From: sara@krdistrict.org
Sent: Friday, April 4, 2025 10:08 AM
To: Ellie Myers
Subject: RE: SP-25-00005 Hanson - Notice of Application

Cc: Jamey Ayling <jamey.ayling@co.kittitas.wa.us>; Zach Torrance-Smith <zach.torrancesmith@co.kittitas.wa.us>; Bradley Gasawski <bradley.gasawski@co.kittitas.wa.us>; Ellie Myers <ellie.myers@co.kittitas.wa.us>
Subject: SP-25-00005 Hanson - Notice of Application

HANSON ROAD SHORT PLAT
 PART OF SECTION 11, T. 17 N., R. 17 E., W.M.
 KITTITAS COUNTY, WASHINGTON

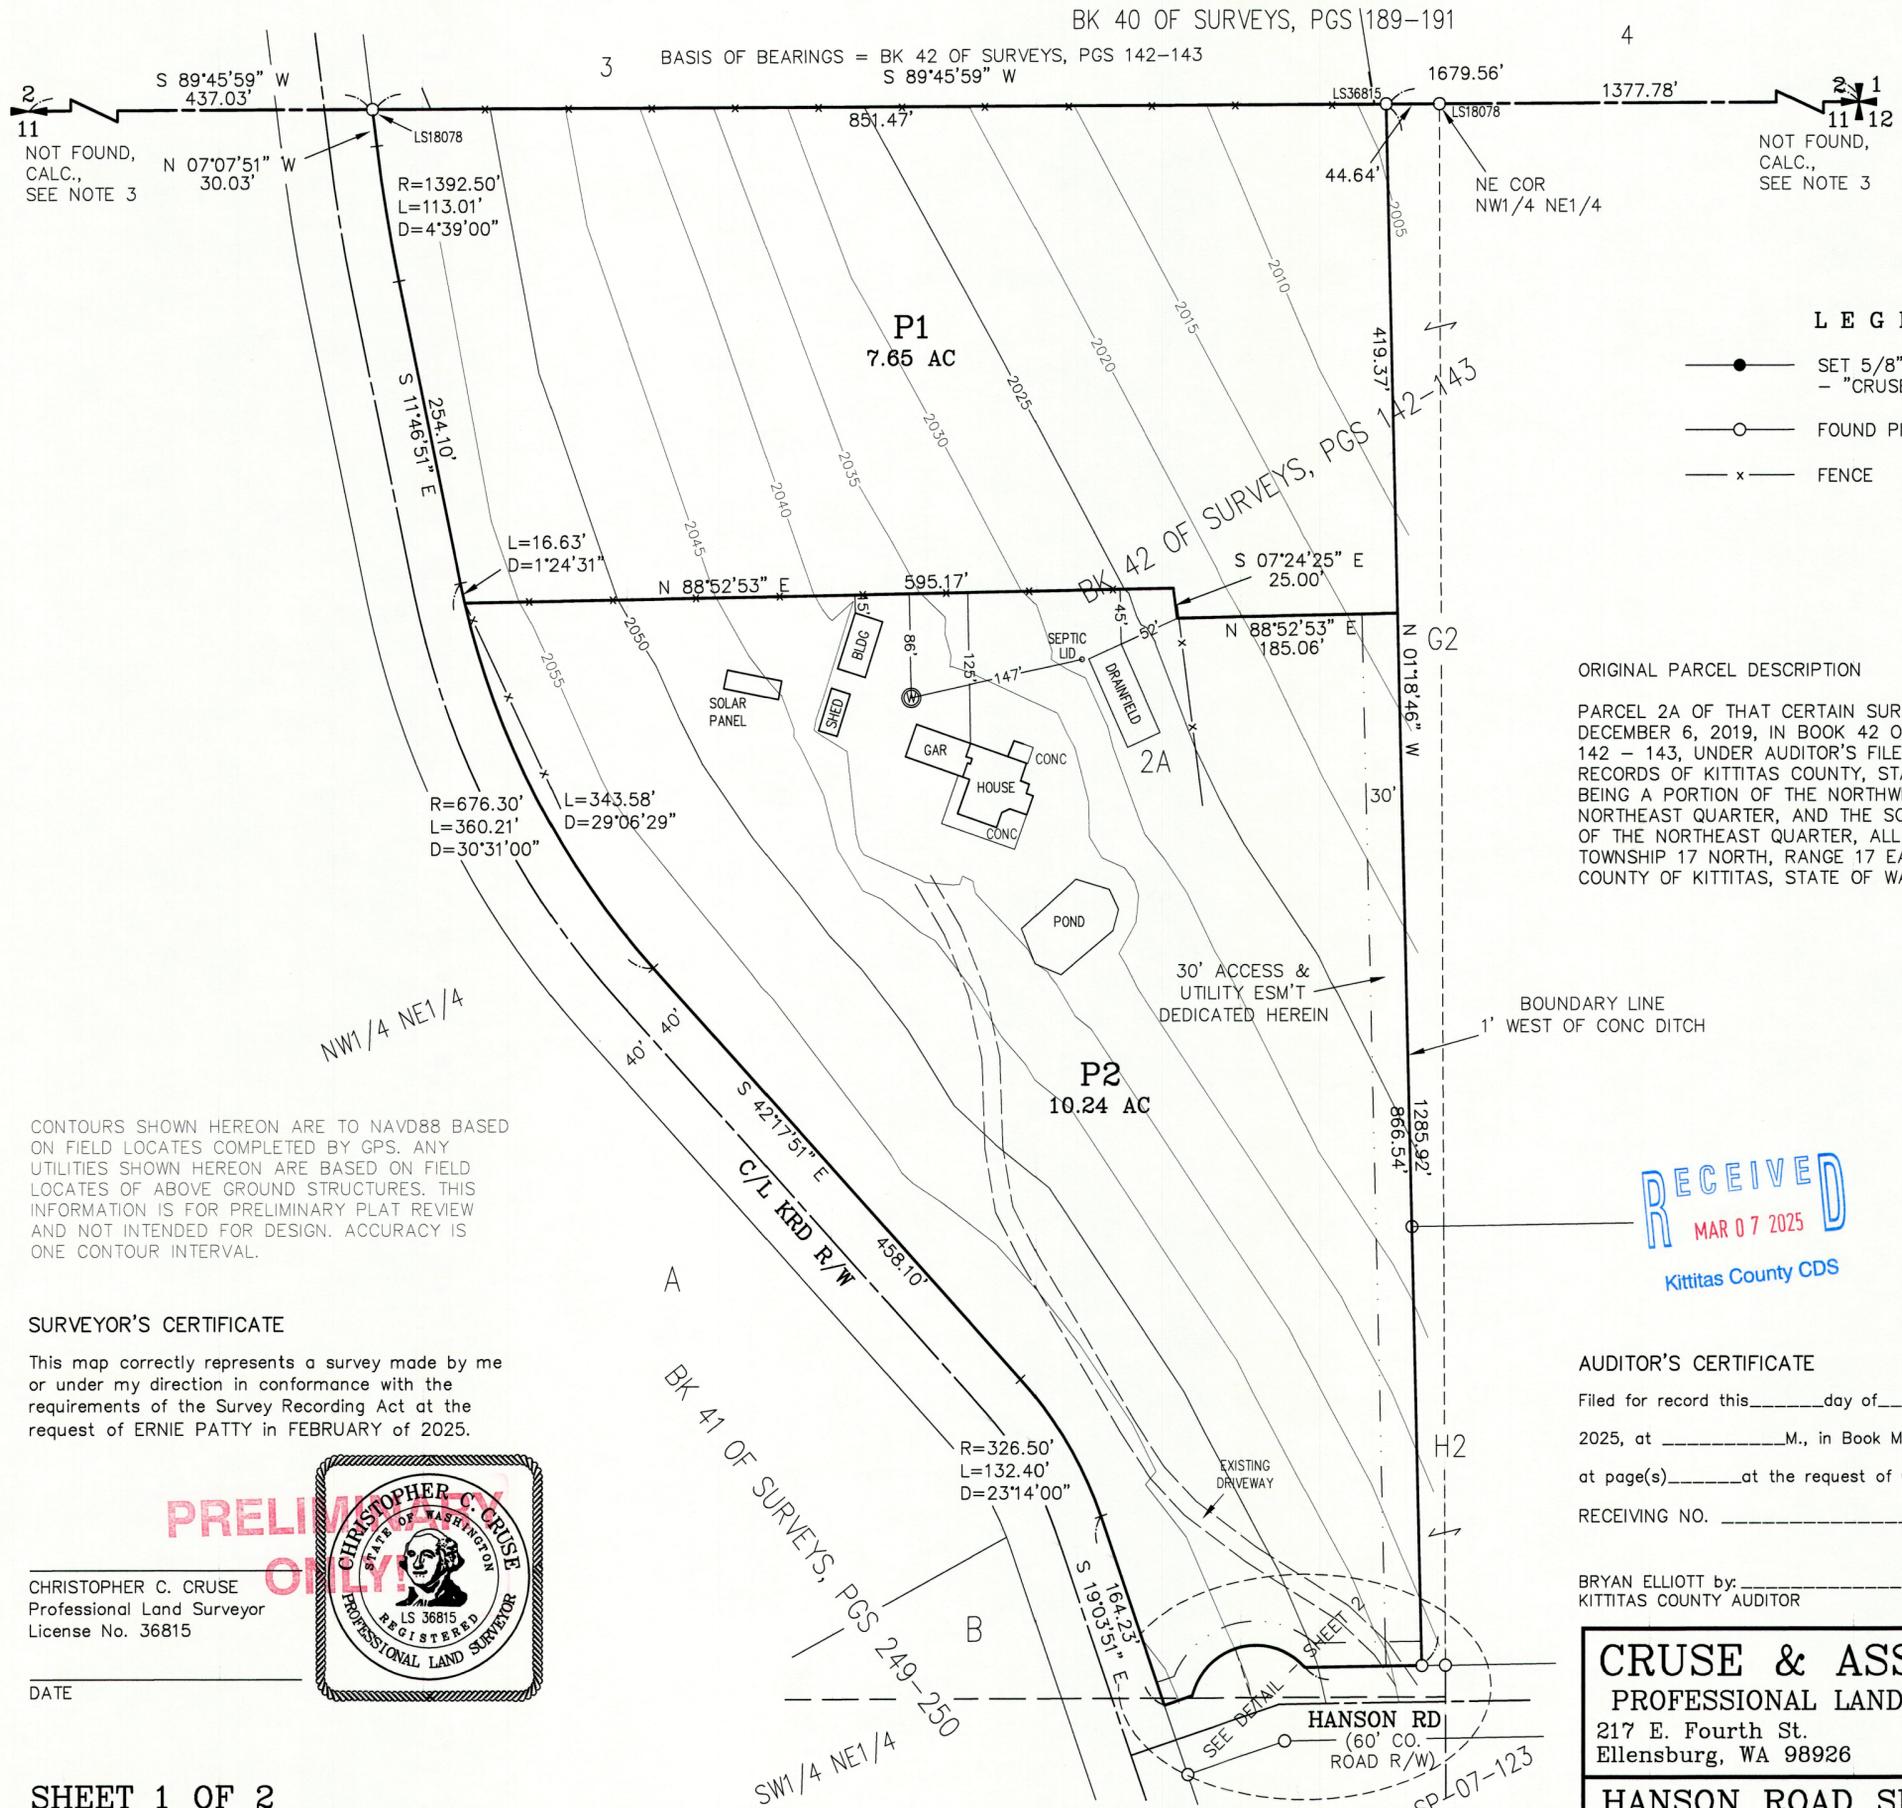
This parcel lies within the Kittitas Reclamation District boundaries and will be required to meet the KRD's Division guidelines. Please contact KRD for a copy of the policy. The landowner will need to work with KRD to develop a Water Distribution Plan ensuring that all parcels are able to receive their irrigation water from the designated diversion on KRD's South Branch Canal. Additionally, the KRD will be piping the South Branch Canal in the Fall of 2025. The diversion for irrigation water will remain the same however there is existing privately owned piping that is lying within the federal right-of-way and will need to be moved to private property for continued use.
